MEMORANDUM

DATE: February 15, 2024

SUBJECT: PUDSP-21-010 – Grandview Reserve (with PSSG)  
Eighth Submittal (“V11”)

GRANDVIEW RESERVE
DR HORTON
 FALCON, COLORADO

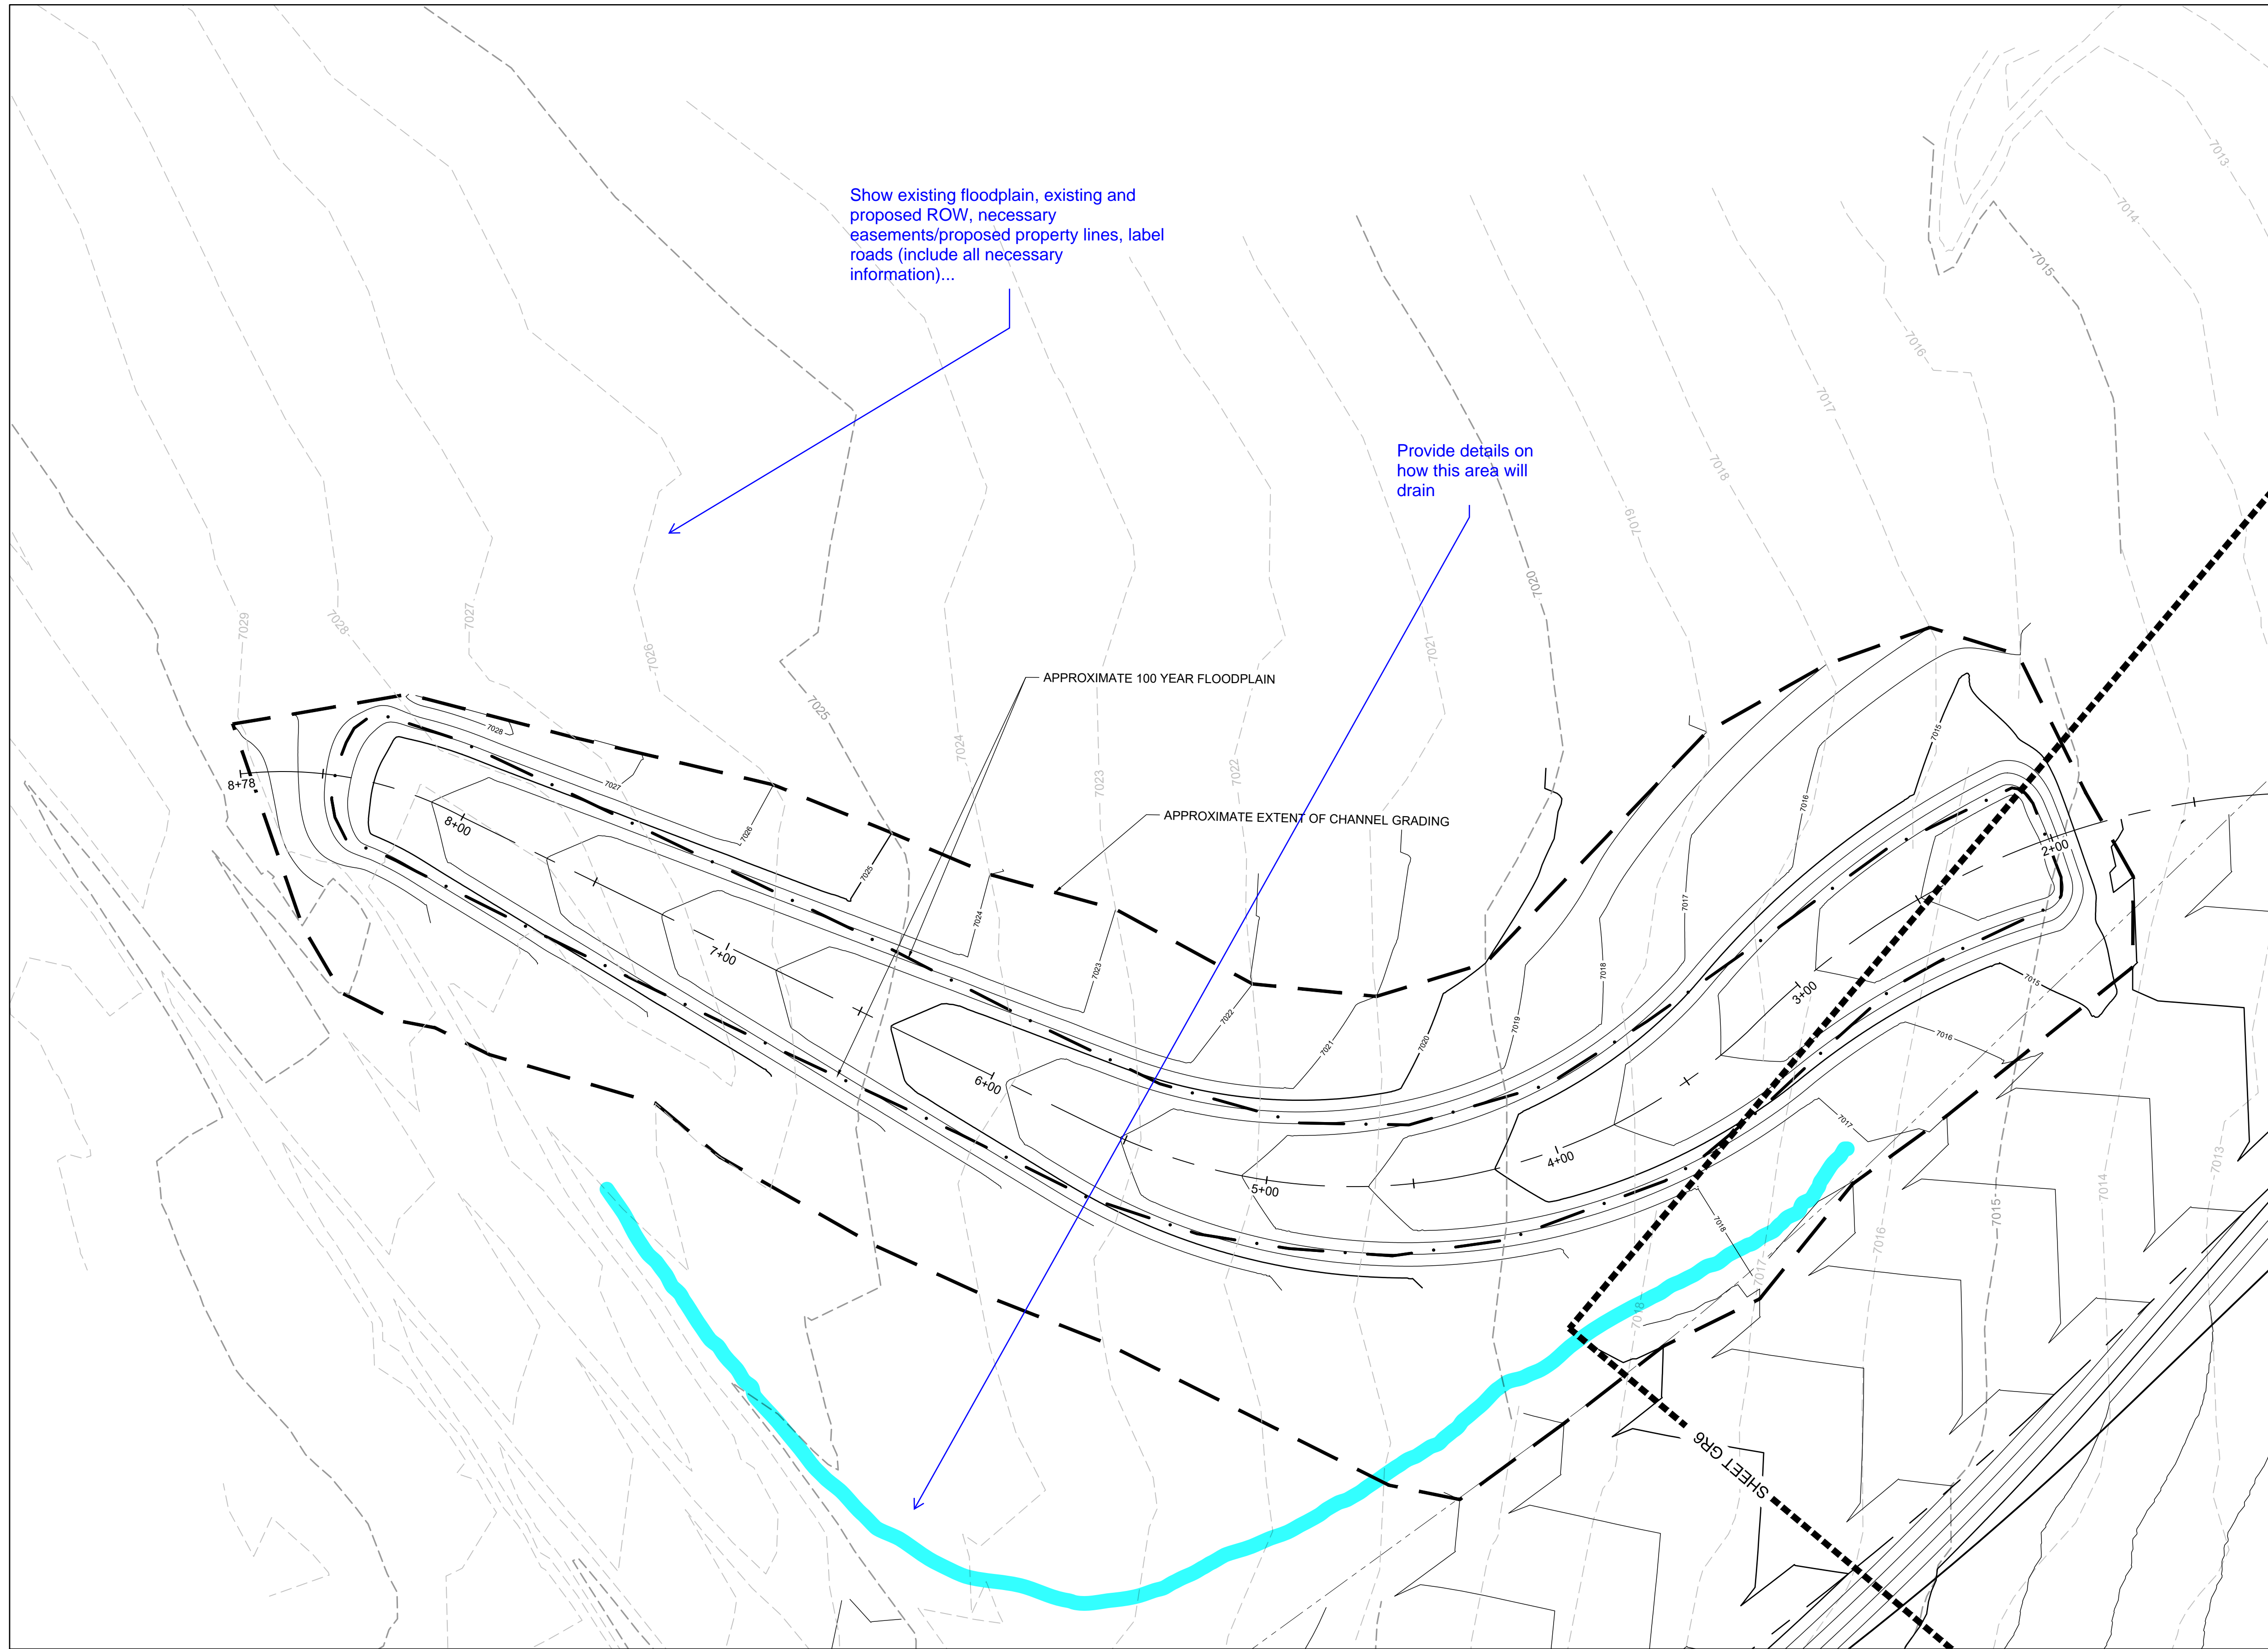
- a. Regarding the "Summary and BOD" document, see email dated 10/8 with cursory comments:
    - i. The cross-section template appears to have been run through the whole channel alignment, creating berms along the channel in some locations. I just want to verify that those will be graded out or widened where appropriate. (see attached redlines highlighting some of the areas of concern). Partially resolved; the grading needs to be completed. **(To be reviewed under CDR-22-008)**

- a. Resolved.
  - b. Berms/levees along the channel next to development areas need to be removed and if fill is added to contain the floodplain it needs to be graded out to an even surface from the edge of the channel (reference CWCB and USACE regulations). **Partially resolved; the very southeast end of the channel is still of concern, with the proposed future Waterbury lots to the south. (To be reviewed under CDR-22-008)**
